Submission of Non-Material Amendment ('NMA') Application: Rothbury STW

Further to our recent discussions, we are pleased to submit on behalf of our client, Northumbrian Water Limited, a Non-Material Amendment ('NMA') application in respect of planning permission ref. 21/00498/FUL at Rothbury STW, Northumberland, NE65 7PL.

"Extension of existing sewage treatment works including erection of operational structures, kiosks, fencing and upgrades to track and hardstanding"

Rothbury STW I&D
New Site Layout Sections
Planning Application

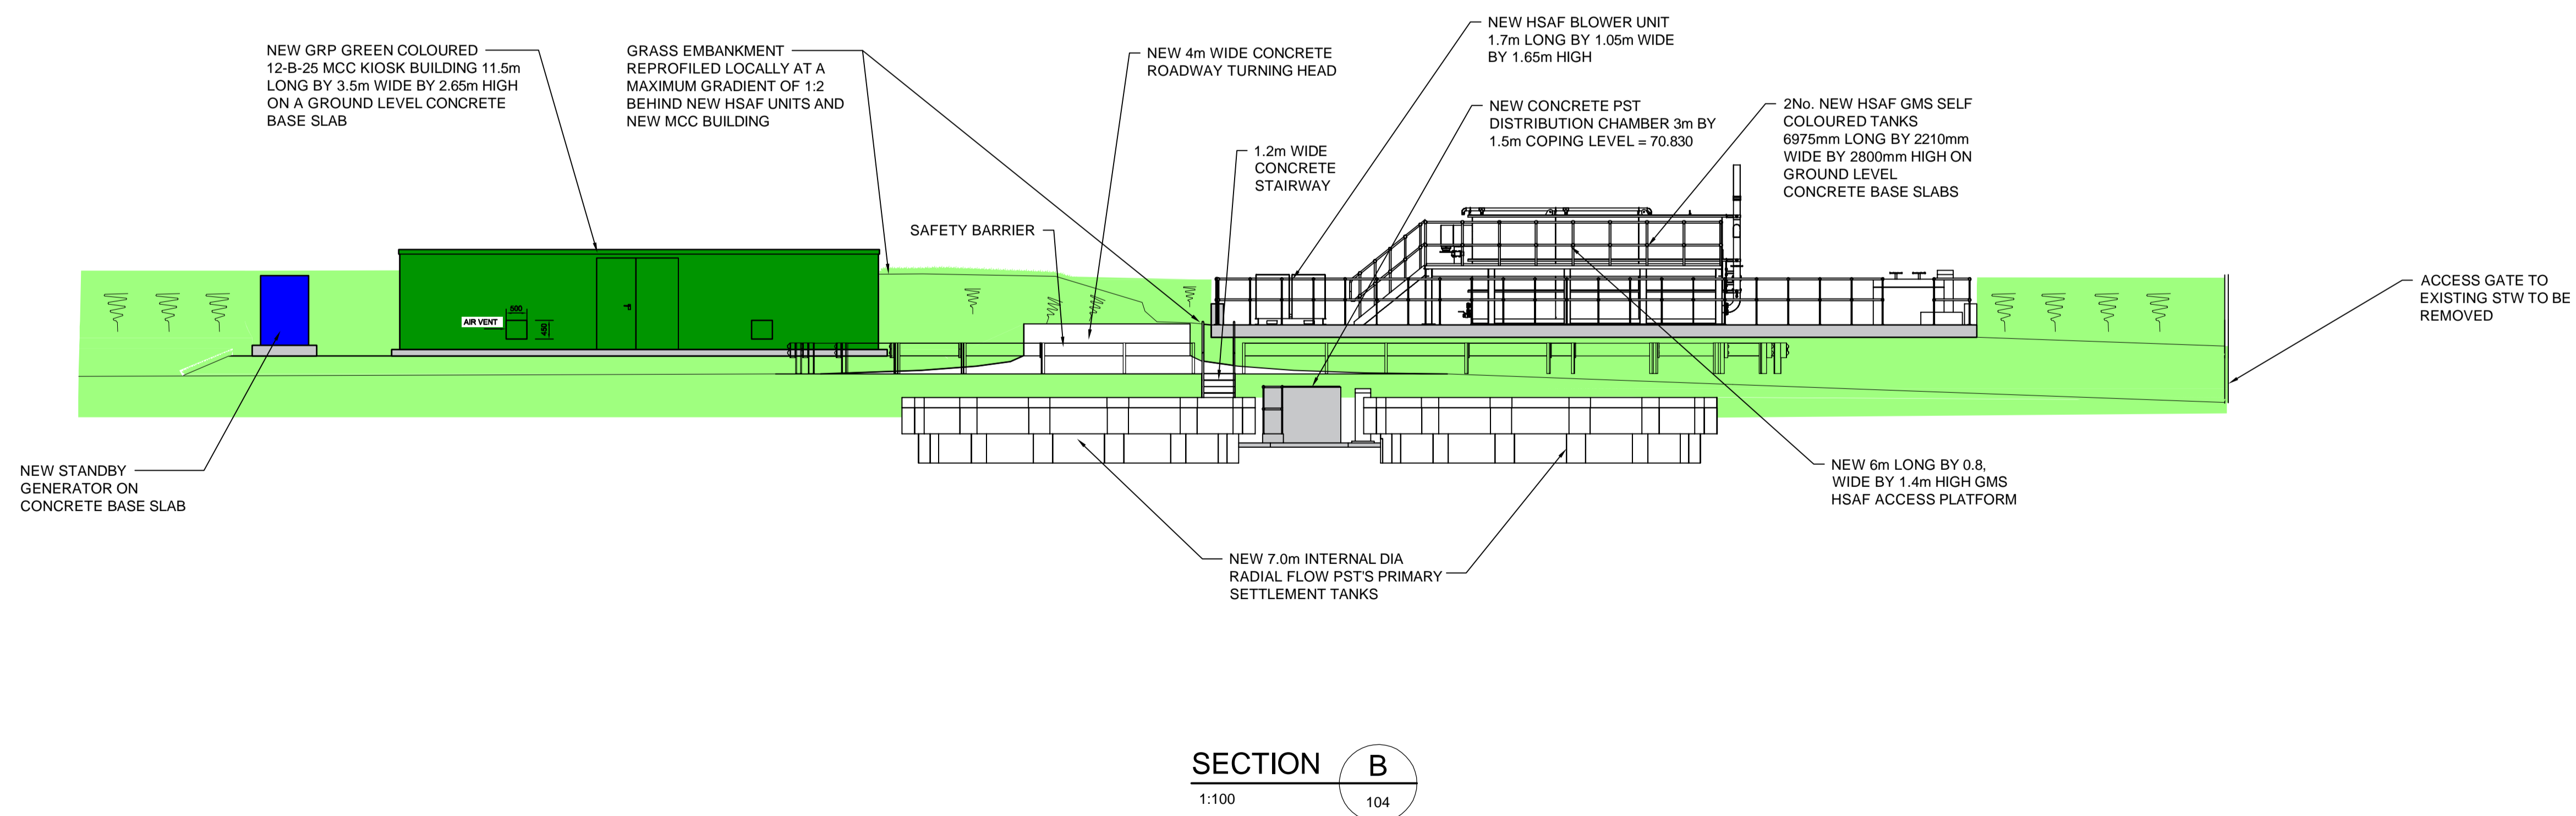
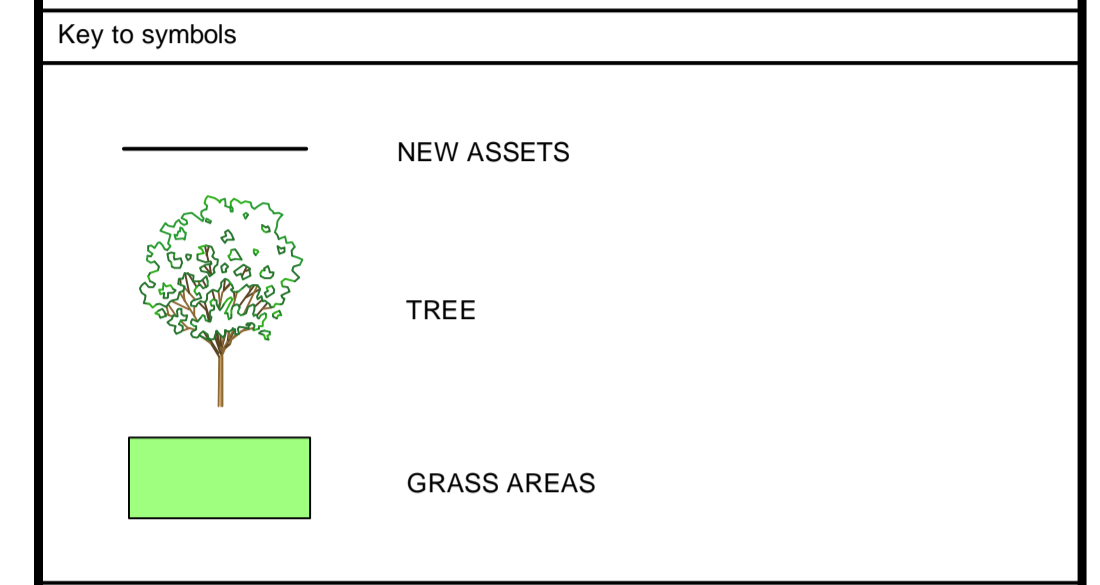
- Relocation of the Final Effluent Sampling Chamber to be adjacent to the HSAF Plant;
- The provision of a vehicle safety barrier along the road above the Primary Settlement Tanks (PSTs);
- Rationalisation of road turning circle radii; reduced area of concrete hardstanding at the PSTs; and reduced internal diameter of the new PSTs from 7.1m to 7.0m;
- The requirement for a new Incoming Power Supply Kiosk (internal dimensions 2100mm long by 750mm wide by 1800mm high) adjacent and to replace the existing kiosk for an increased power supply from NPG;
- The MCERTS flow meter chamber will comprise a manhole with open-mesh decking instead of a rectangular chamber with access cover; and
- Minor changes to proposed Finished Ground Levels and slopes.
